From: Laura Gibbons <Laura.Gibbons@arun.gov.uk>
Sent: 11 January 2022 11:38
To: Planning.Responses <Planning.Responses@arun.gov.uk>
Cc: Simon Davis <Simon.Davis@arun.gov.uk>
Subject: RE: Planning Consultation on: Y/184/21/DOC

Engineers Comments Regarding Condition 8

Application No: Y/184/21/DOC
Registered: 7th January 2022
Site Address: 10 Acre Field Grevatts Lane West Yapton Bognor
Description of Works: Approval of details reserved by condition imposed under ref W/4000394 (Y/103/18/PL) relating to Condition Nos 5 - Construction & Environmental Management Plan, 8 - surface water drainage, 9 - discharge flows to watercourses, 10 - maintenance & management of surface water drainage, 12 - monitoring regime, 13 - landscaping, 14 - materials & finishes, 15 - landscape management plan and 20 - external lighting.

Typical swale/basin gabion outfall detail

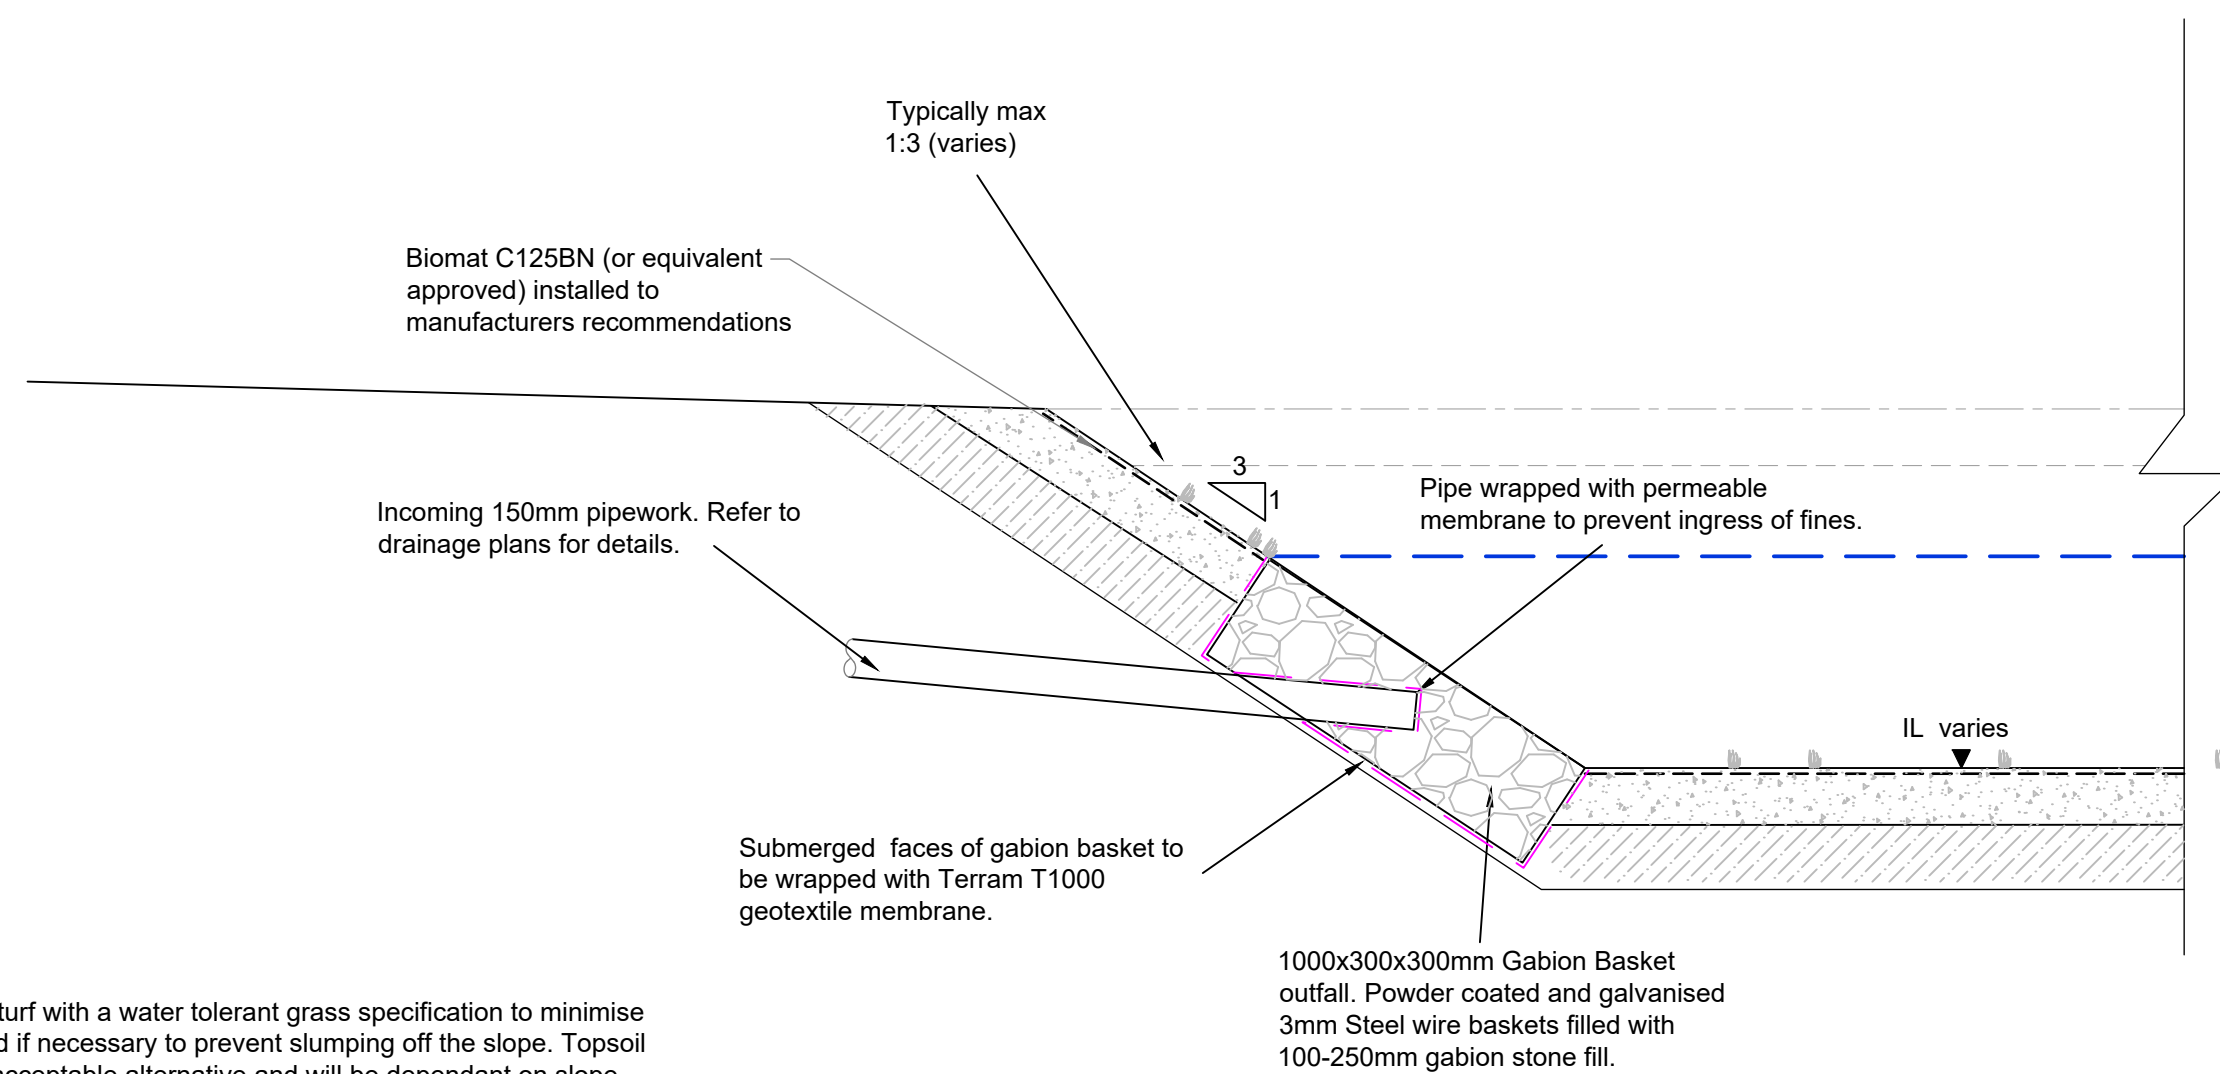
8. The gabion outfall construction detail drawing is unclear. Is it proposed to have buried pipes discharging to the basin?
9. Please supply site specific construction details of the attenuation basin, showing invert level, top of bank level, width at bed and width at bank.

Proposed Foul and Surface Water Drainage Layout

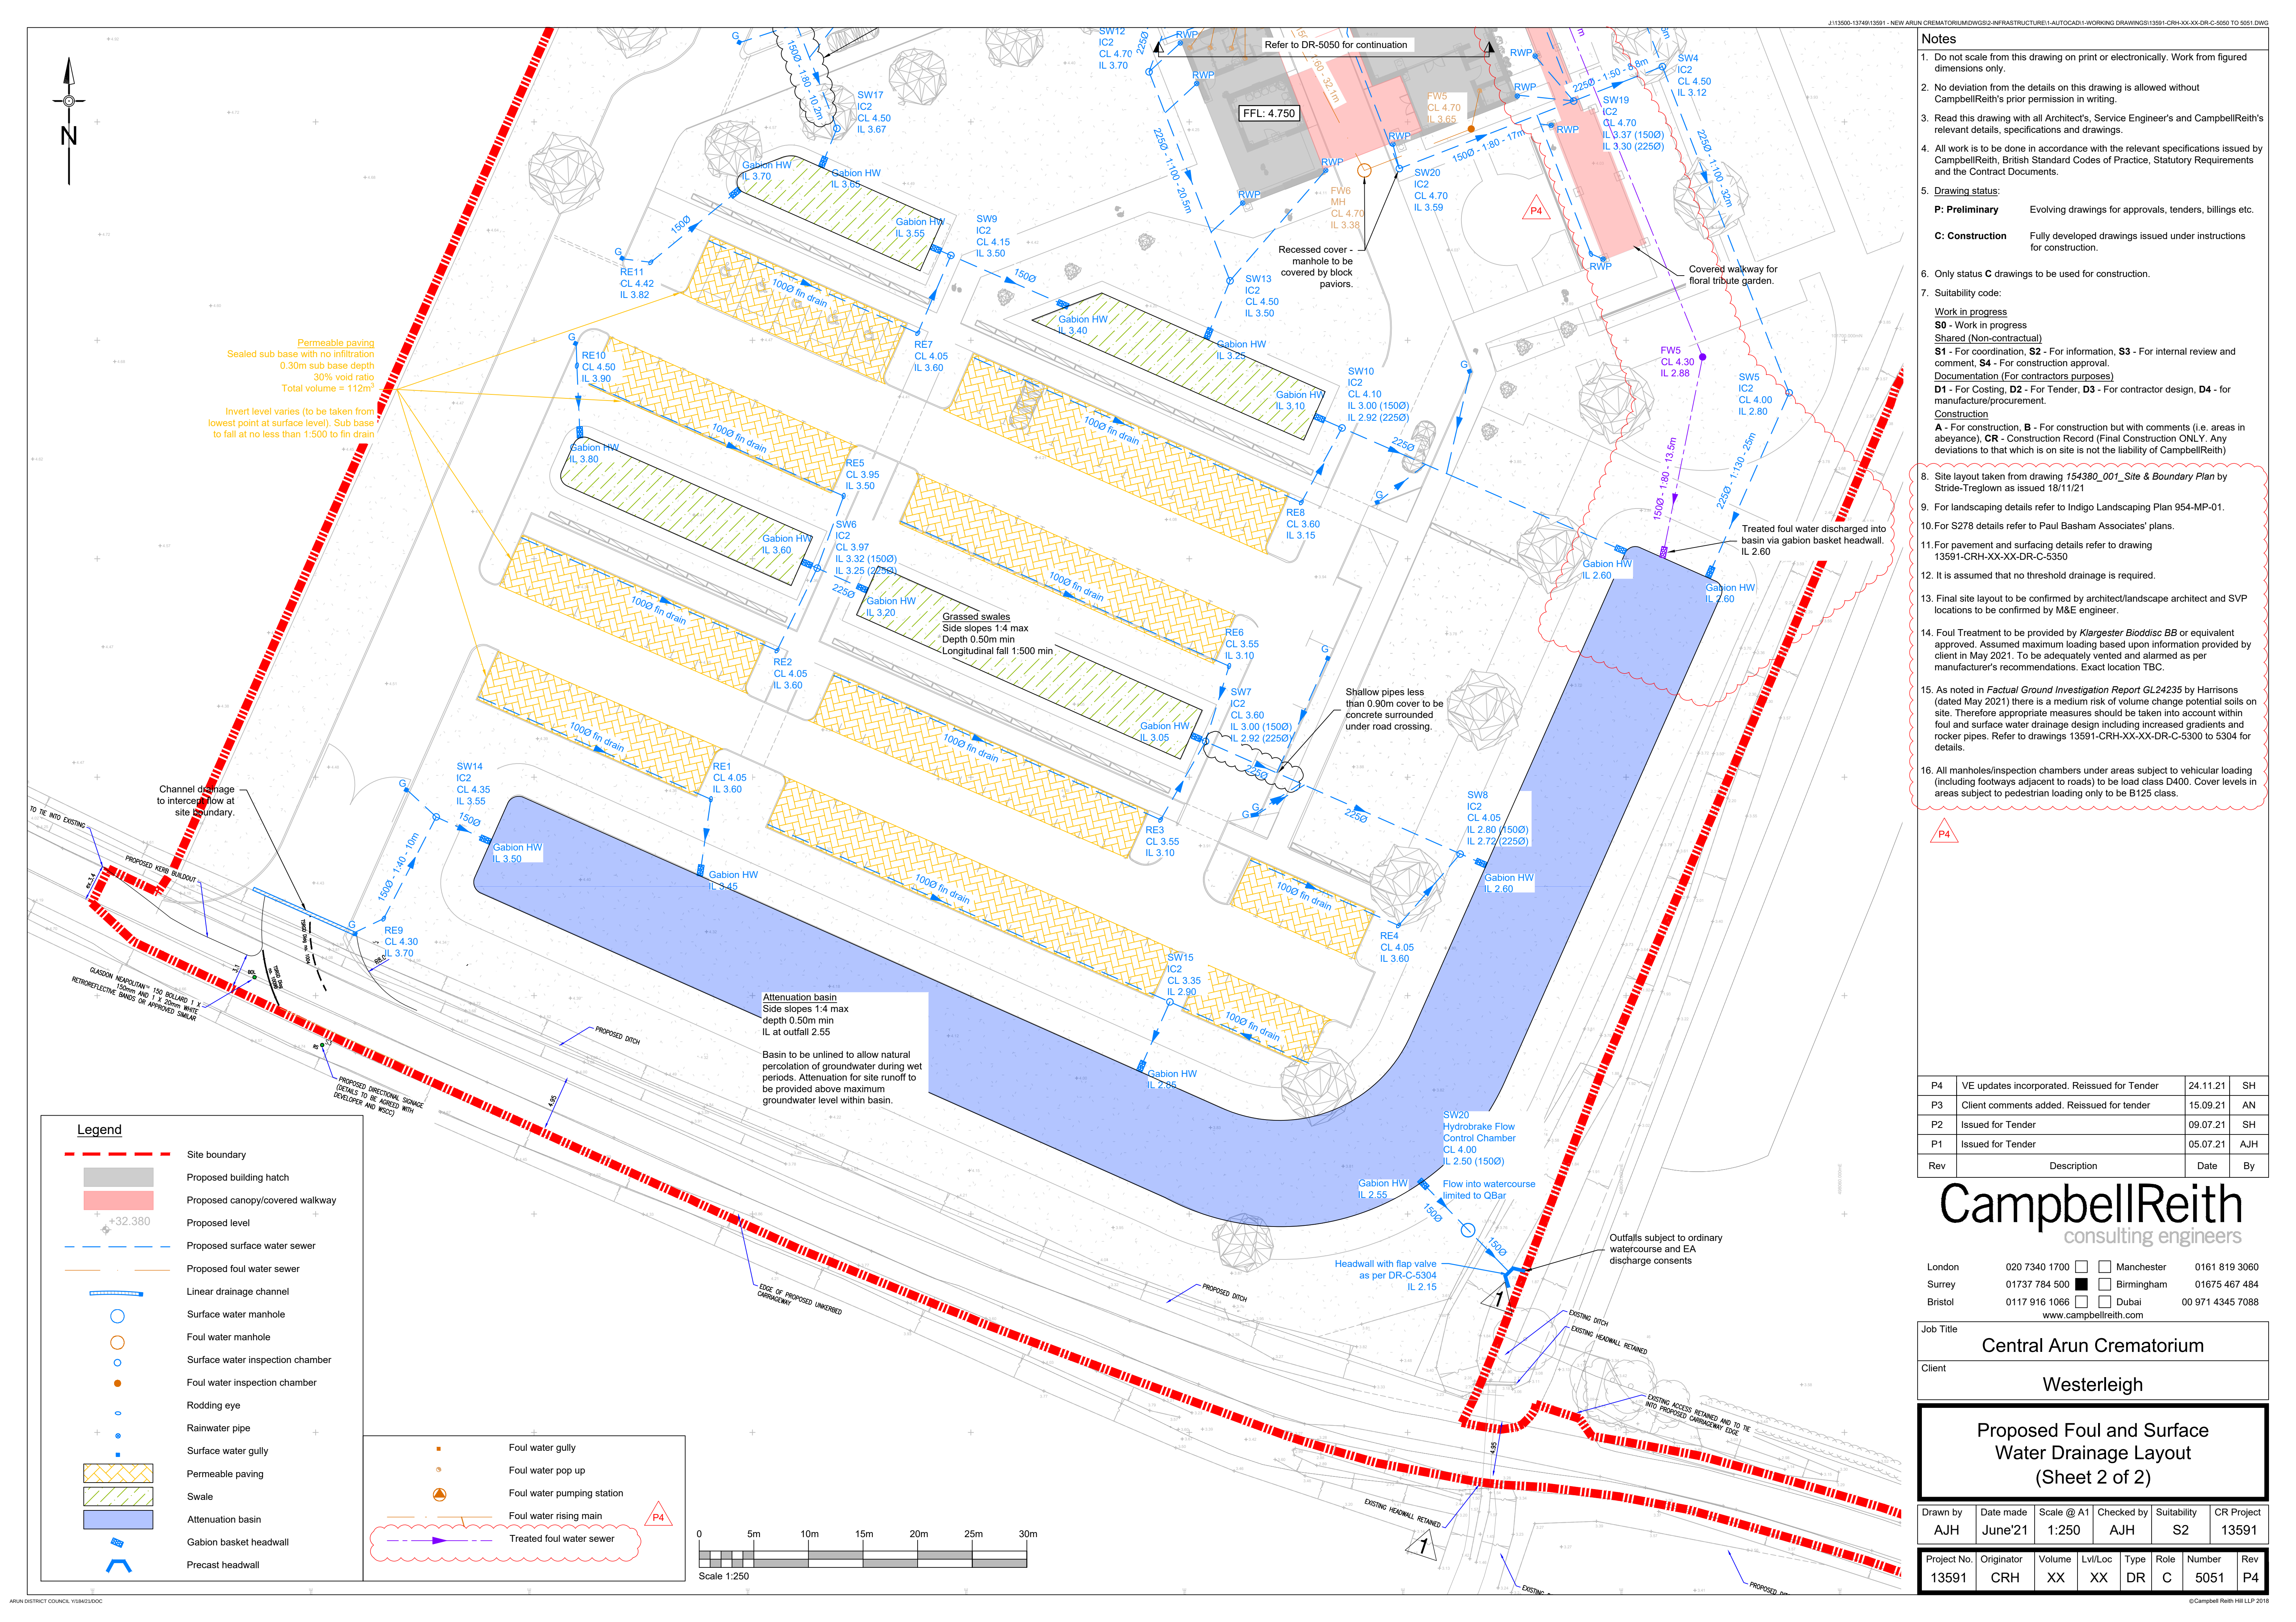
1. Please supply results of winter groundwater monitoring and winter infiltration testing.
2. Please supply calculations to support design.
3. Please supply an impermeable area catchment plan.
4. Please label all pipes with diameter and fall.
5. Hydrobrake unit references should be included on layout plans.
6. Please label finish and formation level of permeable paving.
7. Gullies and channel drains should be labelled with cover levels.
